From: [REDACTED]
Sent: 13 February 2018 09:41
To: Planning.Responses
Subject: BR/311/17/PL Aldwick Rest Home 92 - 94 Aldwick Road, Bognor Regis PO21 2PD

RE: Aldwick Rest Home, 92-94 Aldwick Road Bognor Regis PO21 2PD

Thank you for your correspondence of 15th January 2017, advising me of a planning application for Internal and external alterations for creation of 16no flats for use as emergency housing for which you seek advice from a crime prevention viewpoint.

AL-101

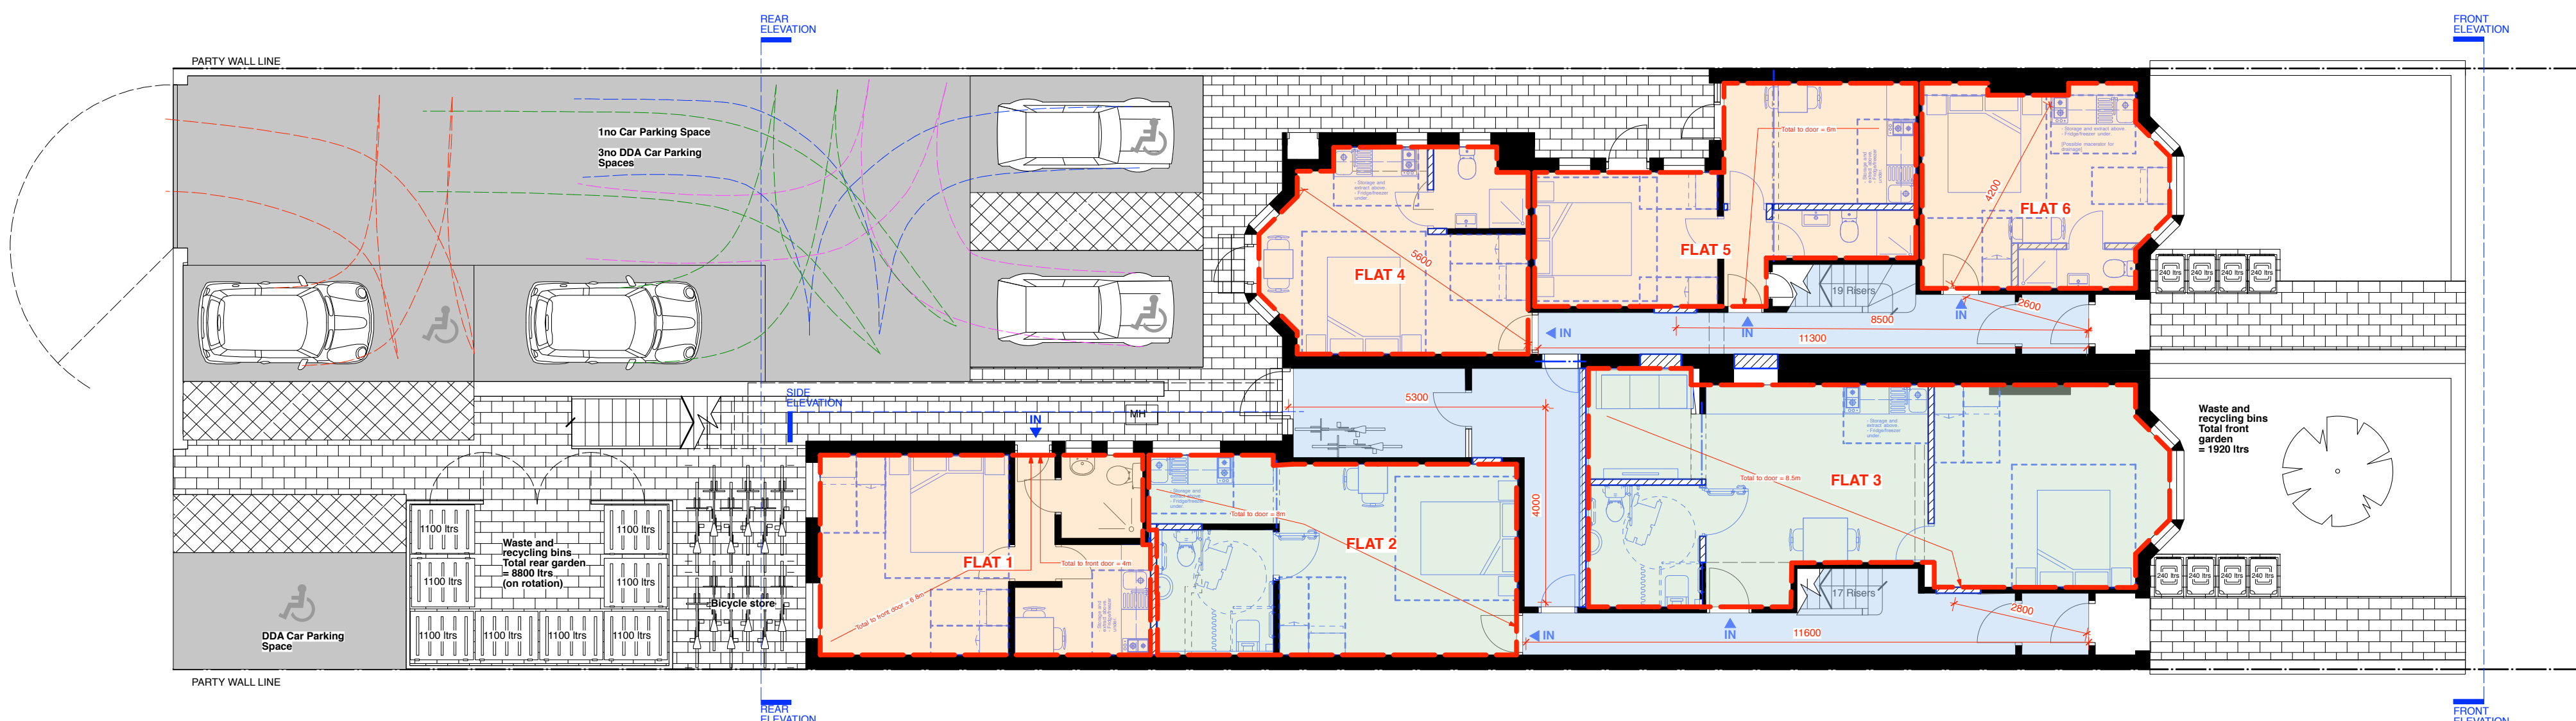
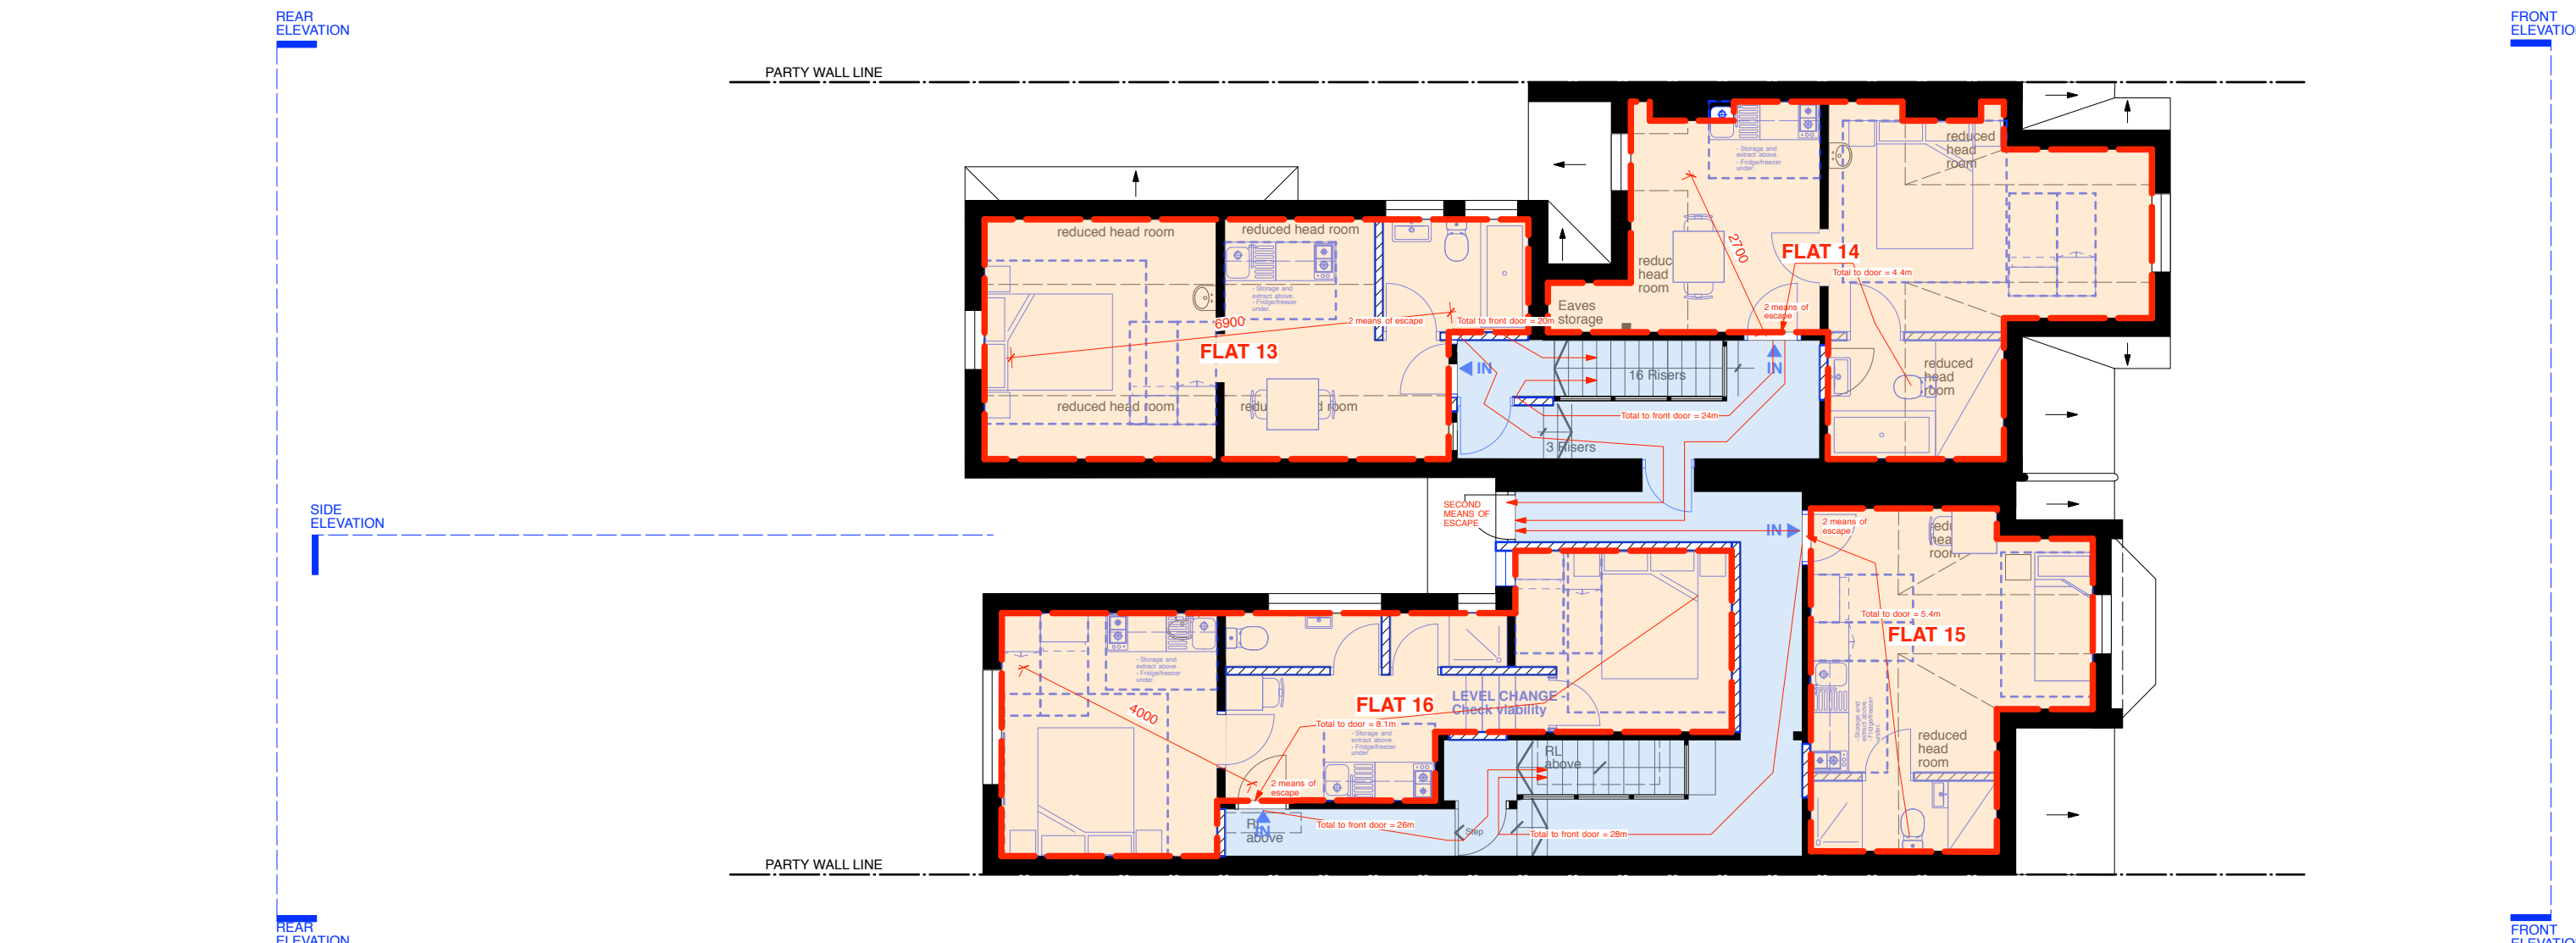
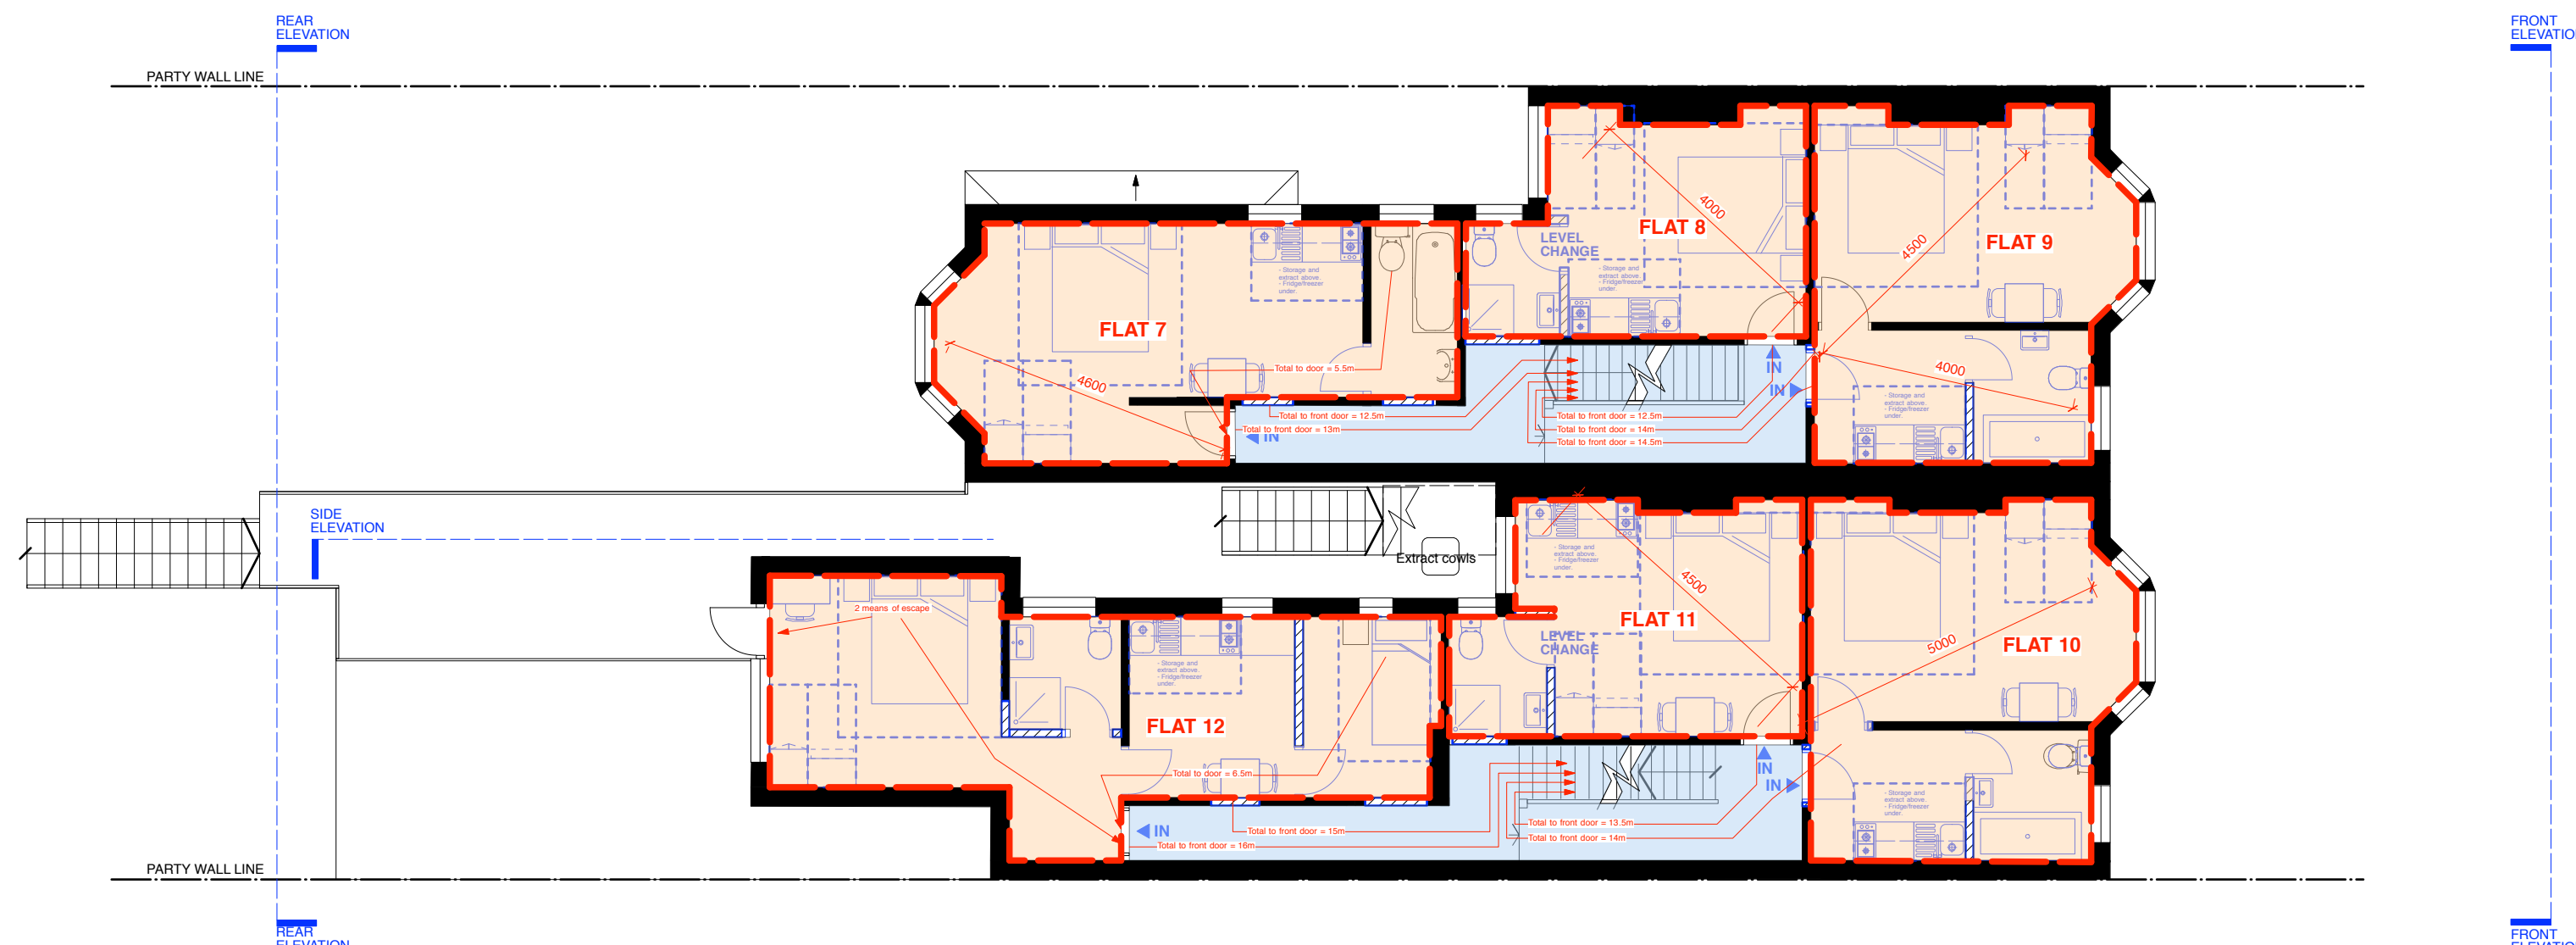
From a crime prevention perspective, it will be imperative that access control is implemented into the design and layout to ensure control of entry is for authorised persons only. SBD recommends that all communal dwellings with more than 10 dwellings or bedrooms should have a visitor door entry system or access control system to enable management oversight of the security of the building i.e. to control access to the building via the management of a recognised electronic key system. It should also incorporate a remote release of the primary entrance door set and have audio visual

SBD recommend all door sets giving access to the building including front and rear doors and frames should be certified to one of the following standards PAS24:2012 or PAS24:2016 STS 201 or LPS 1175 Issue 7 SR2.

From a crime prevention perspective, internal doors to individual bedrooms should be of robust construction and fire rated installed with a lock certified to BS 8621 or PAS 8621, fitted with a security door chain, door viewer and two hinge bolts.

I recommend the postal arrangements for the flats are through the wall, external or lobby mounted secure post boxes. I strongly urge the applicant not to consider letter apertures within each flat front door. The absence of the letter aperture removes the opportunity for lock manipulation, fishing and arson attack and has the potential to reduce unnecessary access to the block.

5 PROPOSED REAR ELEVATION
1:100

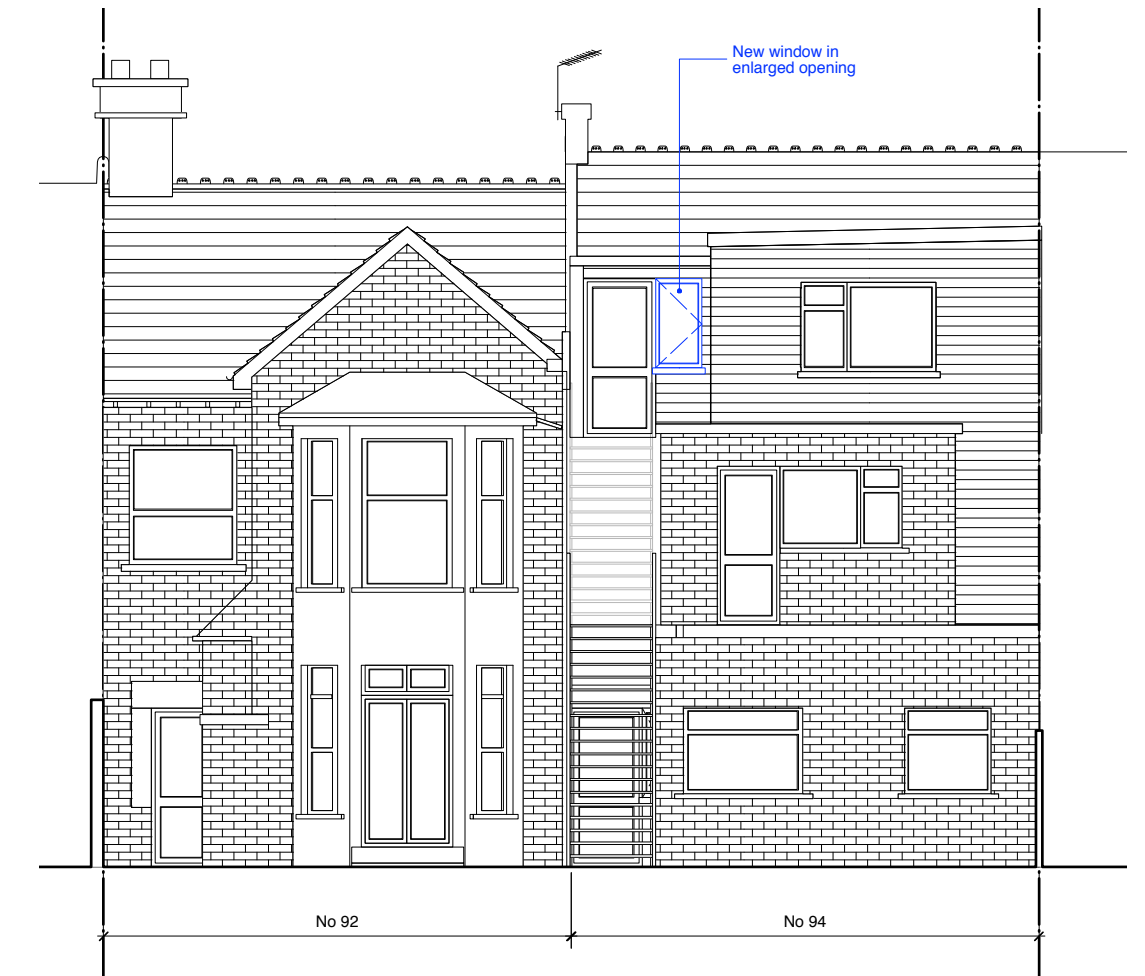
At the rear of the property the yard should be illuminated with lighting to the relevant levels recommended by BS 5489:2013 and with access control on the back gate. Walls gate and fencing should be a minimum of 1.8m high to deter climbing.
